WEST SUSSEX COUNTY COUNCIL CONSULTATION

TO:	Arun District Council FAO: Claire Potts
FROM:	WSCC - Highway Authority
DATE:	10 th May 2022
LOCATION:	Barnham, Eastergate, Westergate BEW Parcel SC1 Barnham
SUBJECT:	BN/11/22/OUT Outline application with all matters reserved (except for the A29 Realignment) for the demolition of existing structures and mixed use development to provide residential dwellings (Use Class C3), Care Home/Senior Living Accommodation (Use Class E/F2/Sui Generis), a Primary School plus open space, landscaping, drainage and all other associated ancillary works; and realignment of the A29 and early connection to existing A29 including construction of a new road carriageway, junctions and associated infrastructure. This application also lies within the parish of Aldingbourne, affects the setting of listed buildings, affects the character & appearance of the Eastergate Church Lane Conservation Area and affects a Public Right of Way. This application is the subject of an Environmental Statement.

A29 BEW Rail Bridge (WSCC structure ref: 1779).

A29 BEW Lidsey Rife Viaduct (WSCC structure ref: 1780).

Drawing Title
**INITIAL BRIDGE OPTIONS
MULTI SPAN**

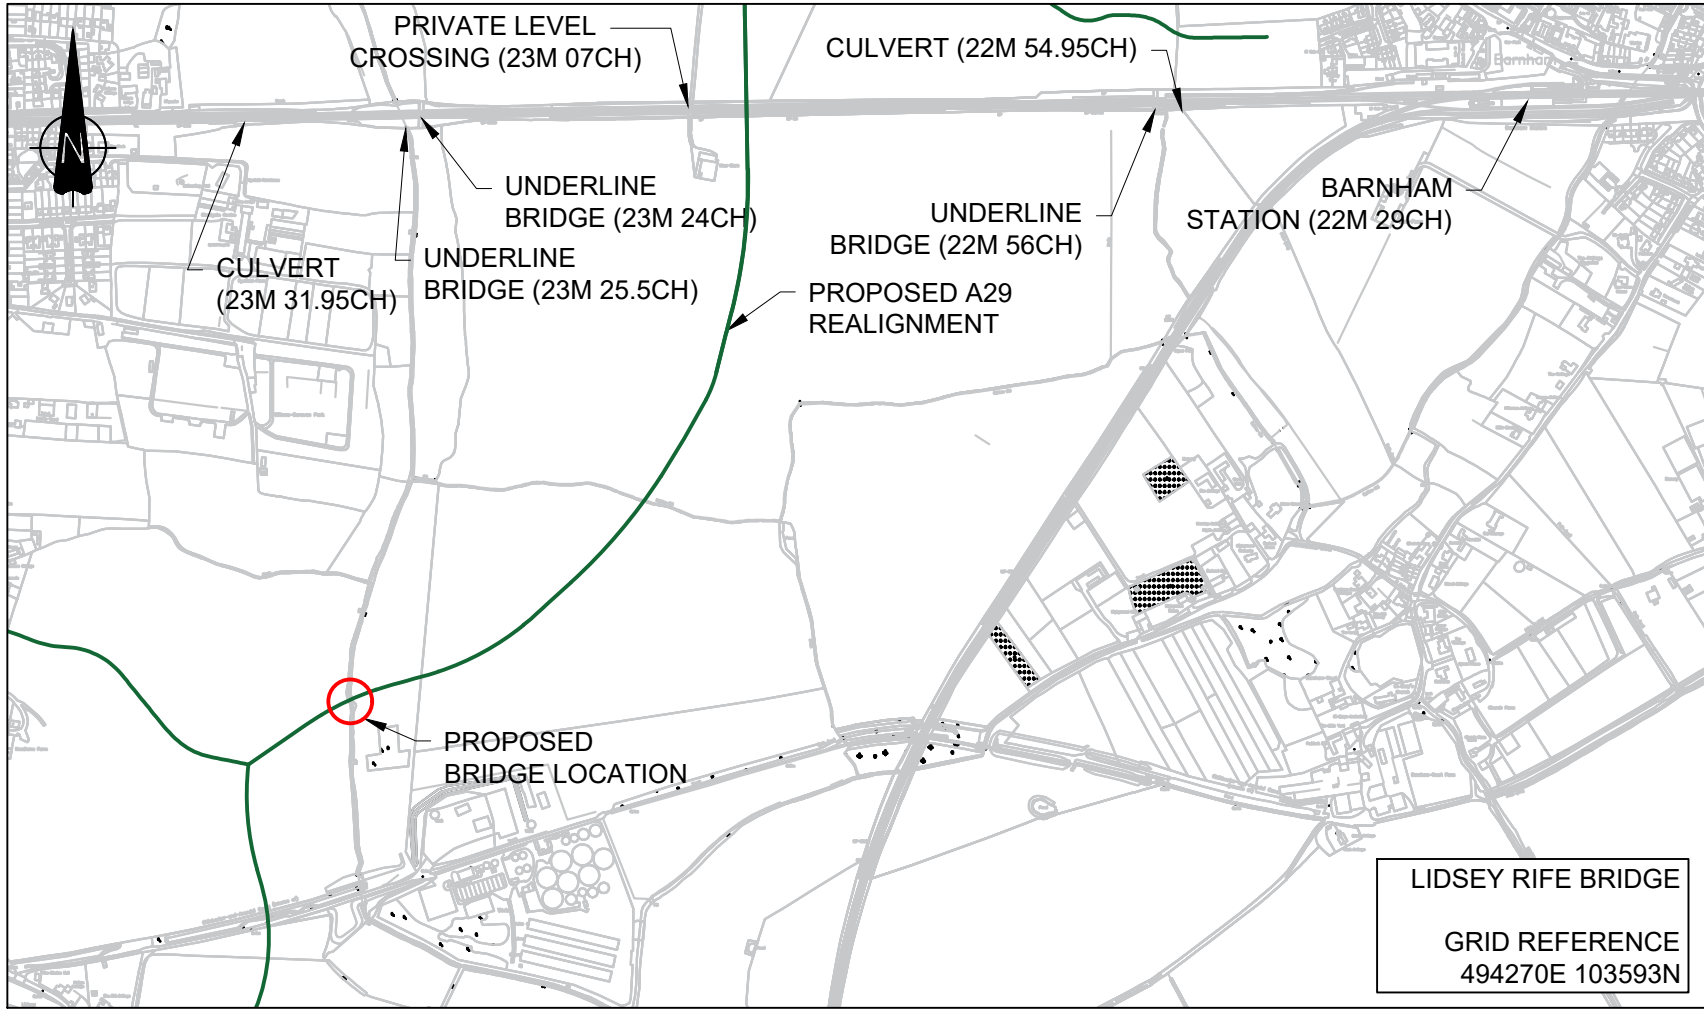
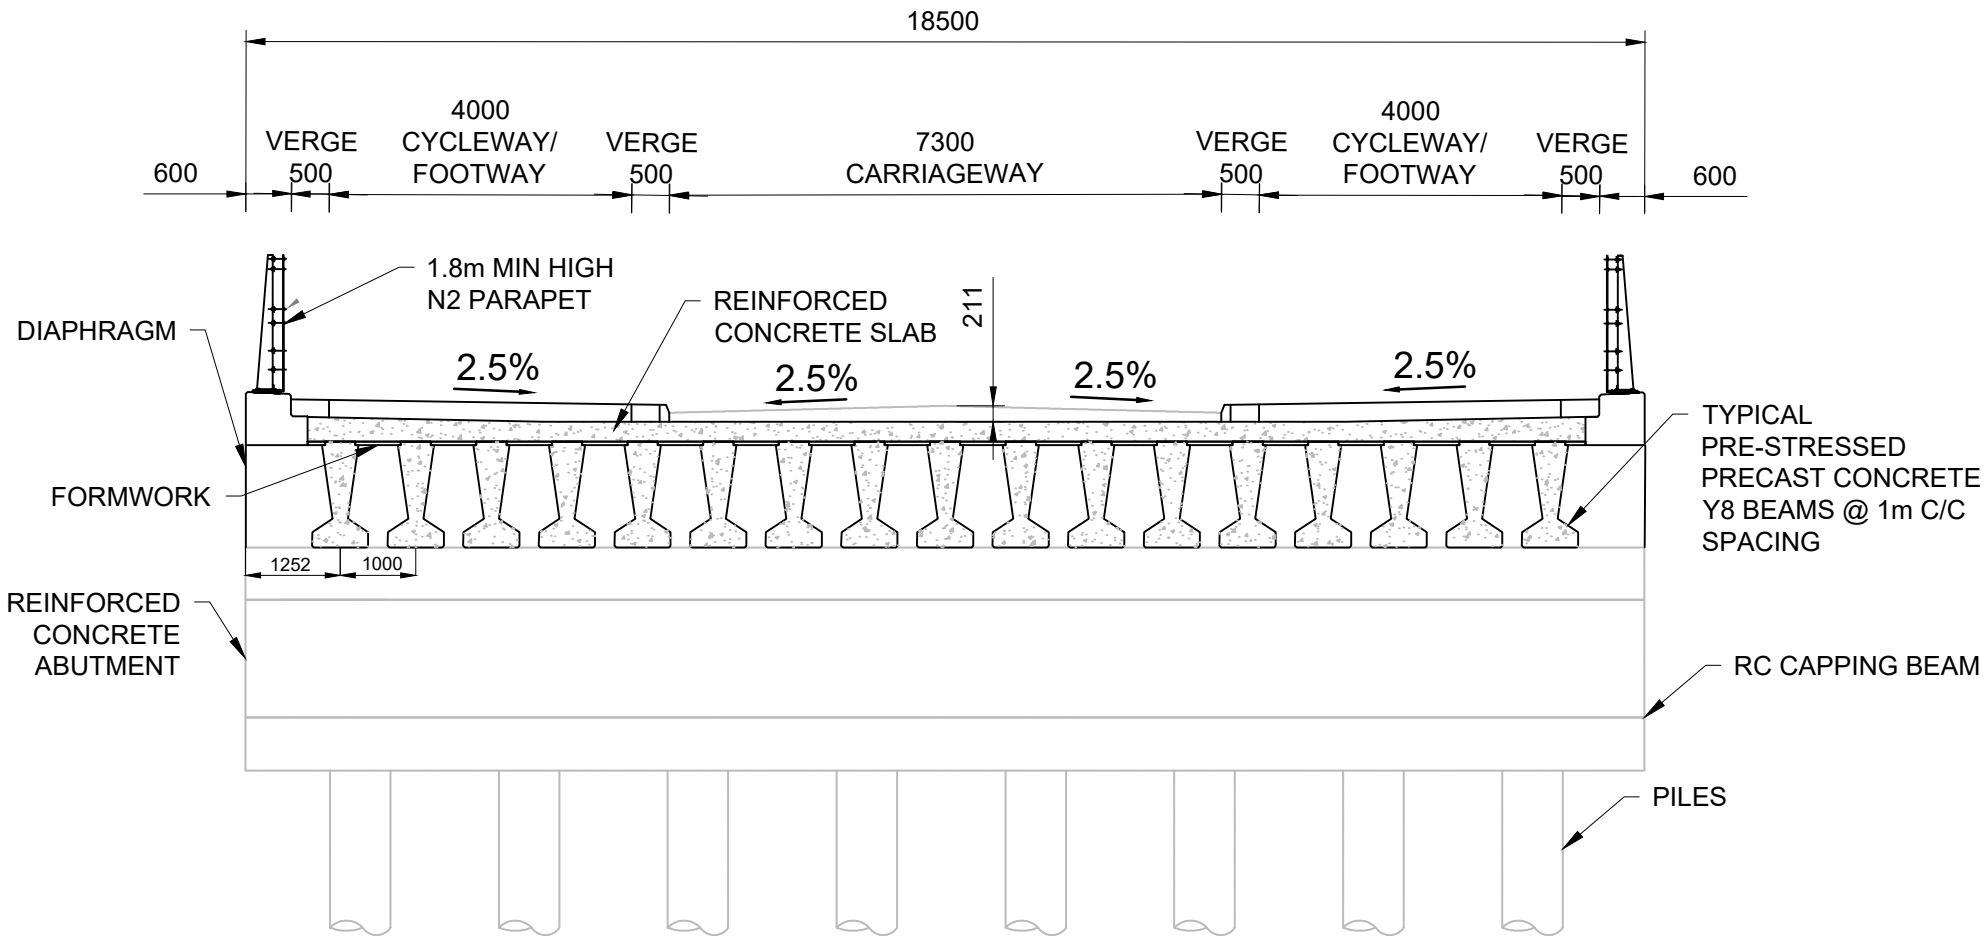
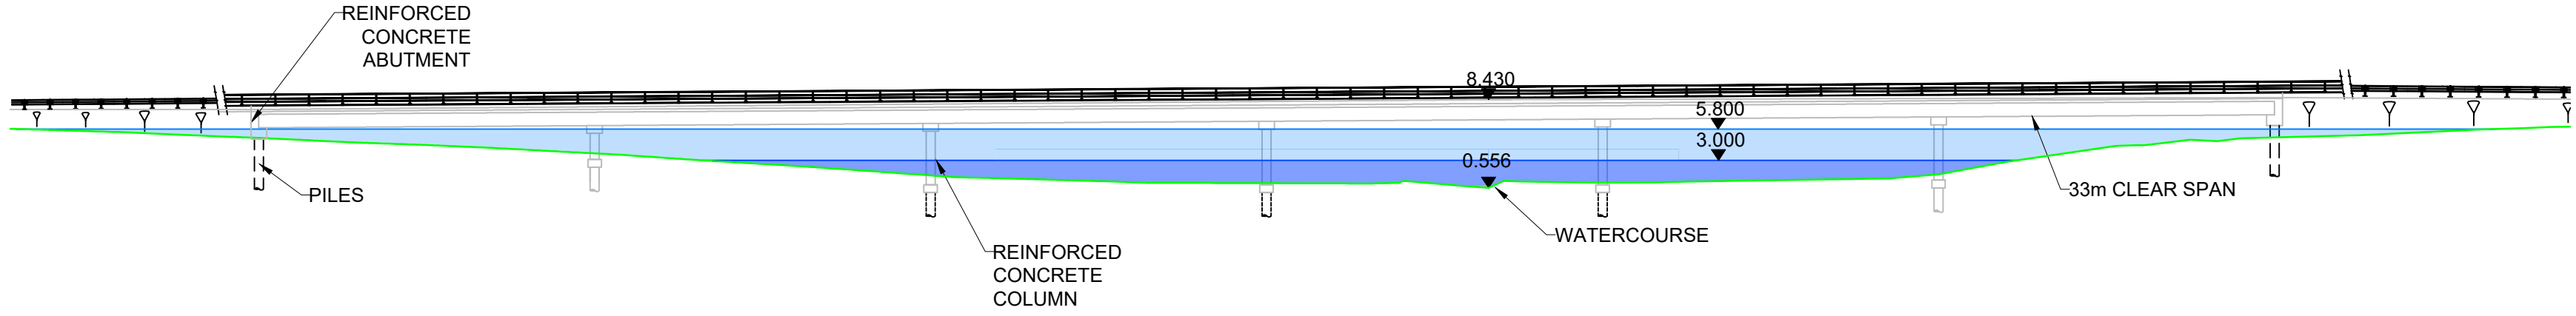
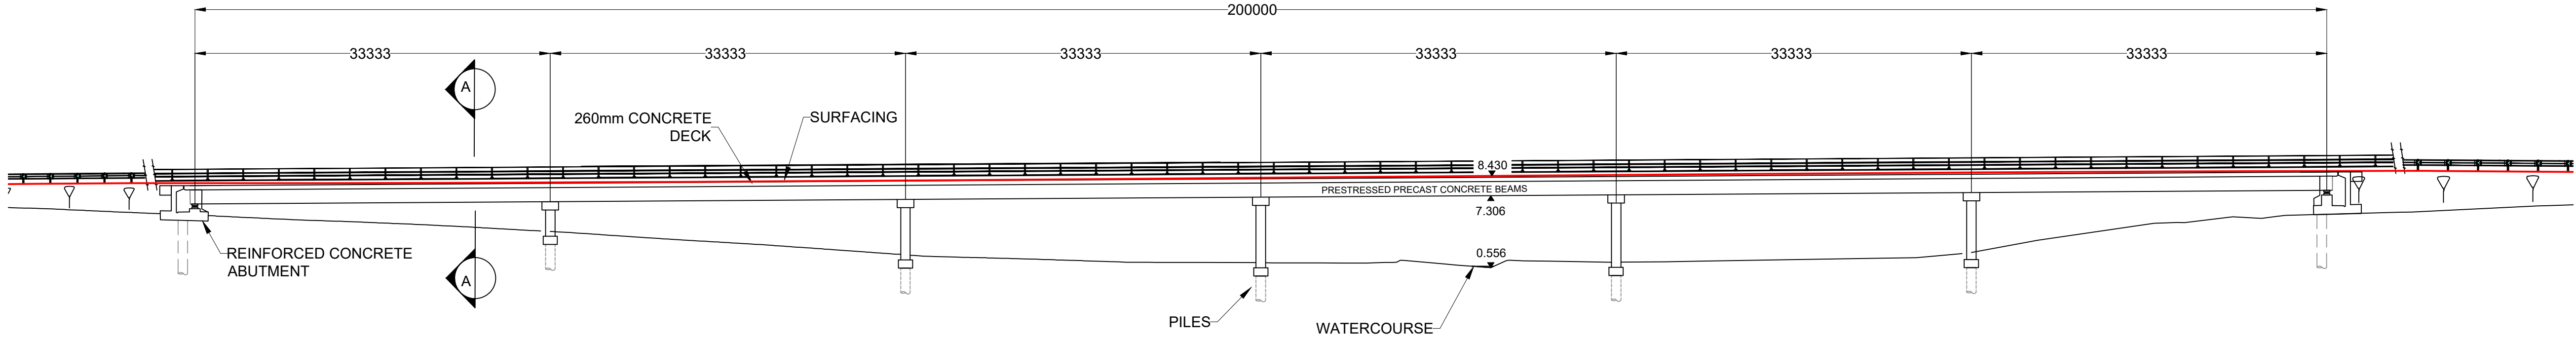
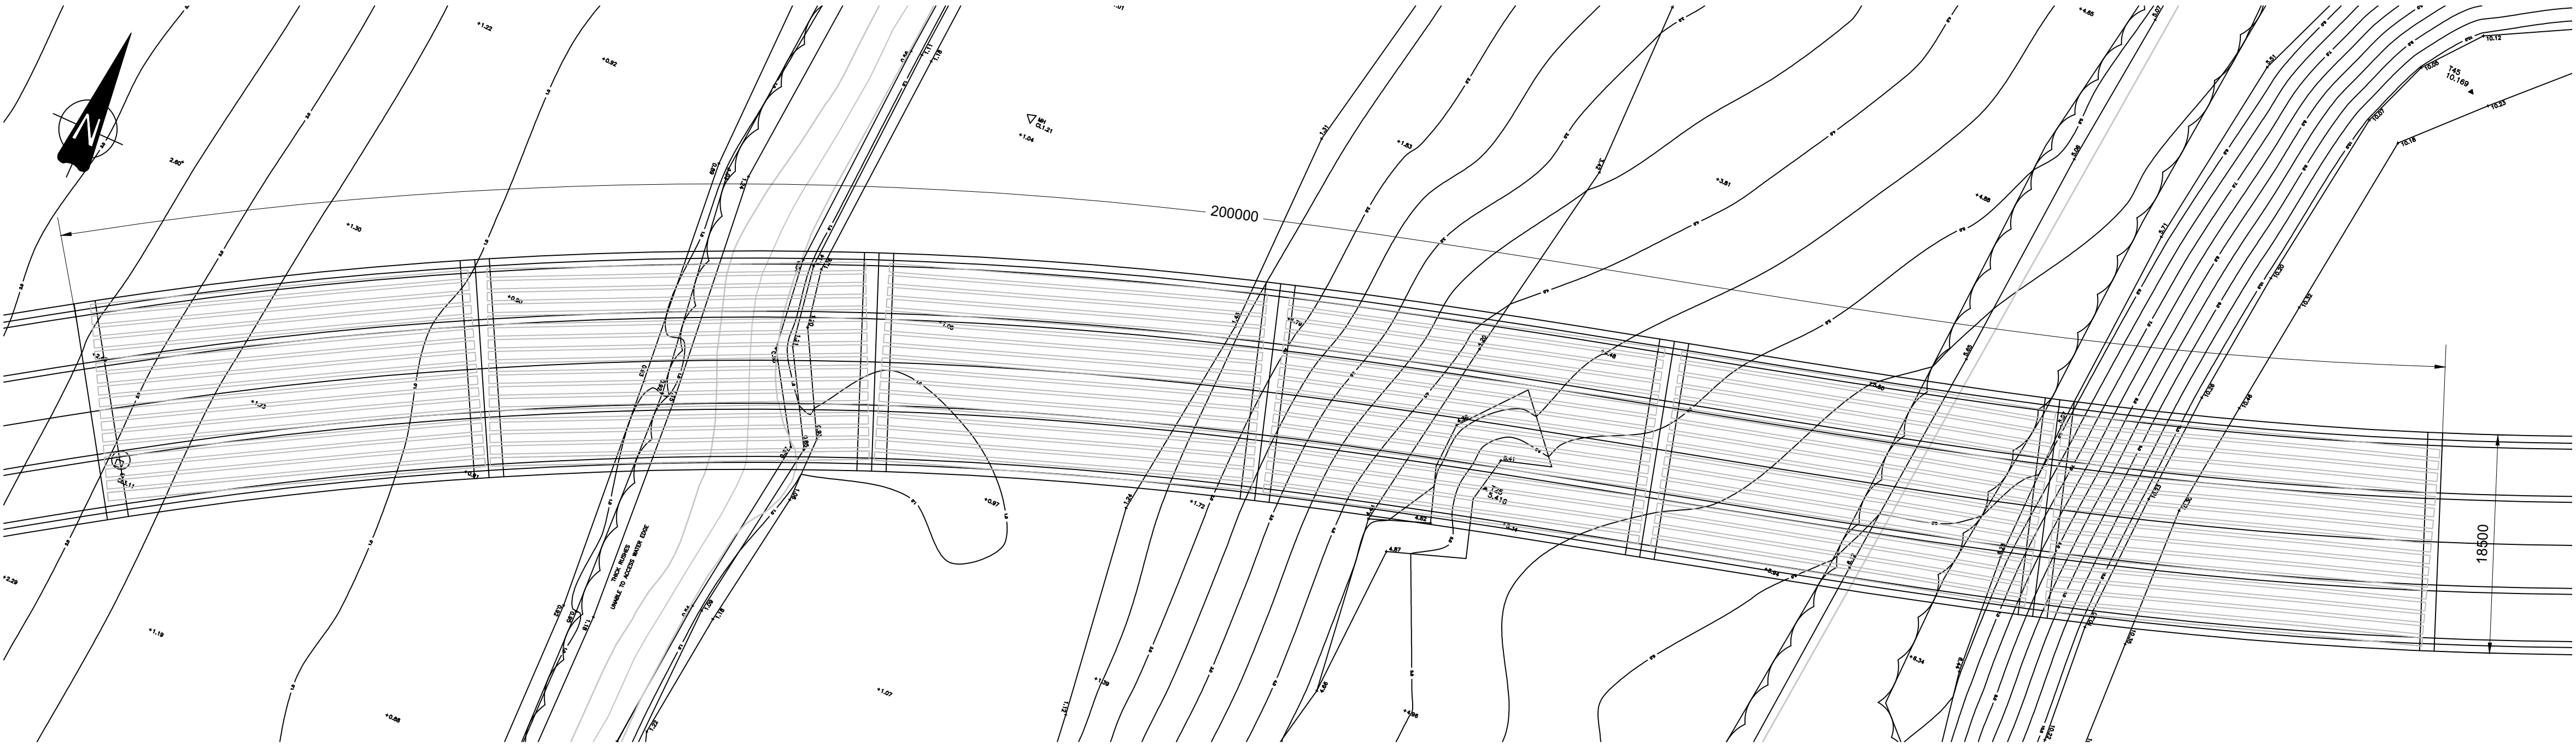
The Technical Note (TN) is geared towards either a) a 200m long multi-span viaduct, or b) a 30m single span structure. The reason for the massive variance is as stated in the front of the report, see screen grab below.

Given as much, the vast majority of the content of the TN is of limited use as it only discusses 1 No. viable option. The TN should have addressed various single span options (e.g. weathering steel, U or W beams similar to the Options Report for the rail bridge). As a result, the drawing is certainly of interest but also of limited value (in the context of 'options'). Perhaps the rife bridge could basically be a repeat of the rail bridge (the widths should be identical and the spans are very similar)?

- a. Refer to general comment above regarding NMU route type.
- b. The WSCC naming convention for the bridge needs to appear on all doc' headers and drg title blocks. Again, the name should be clear/specific but the 'WSCC structure ref: 1780' must appear.
- c. It is appreciated that deeper beams result in more fill on the approaches, but with Y6 beams at 1.0m centres there is not enough space between the beams to inspect the inside faces (gap is currently approx. 250mm). Deeper beams at larger centres are necessary.

- d. The cantilevers look too wide given how thin the deck slab is(?).
 - e. Typically with a Y beam deck there are YE beams.
 - f. Ideally, WSCC would require inspection & maintenance access points to the underside (steps down the embankments at diagonally opposite corners?).

- g. The report touches on the lack of clashing with existing services, but what about new services? There is not a lot of fill to accommodate larger diameter mains. It is appreciated that this is the first submission but WSCC would like to see something on the drawing that is indicative and calls up that the utilities are TBC.
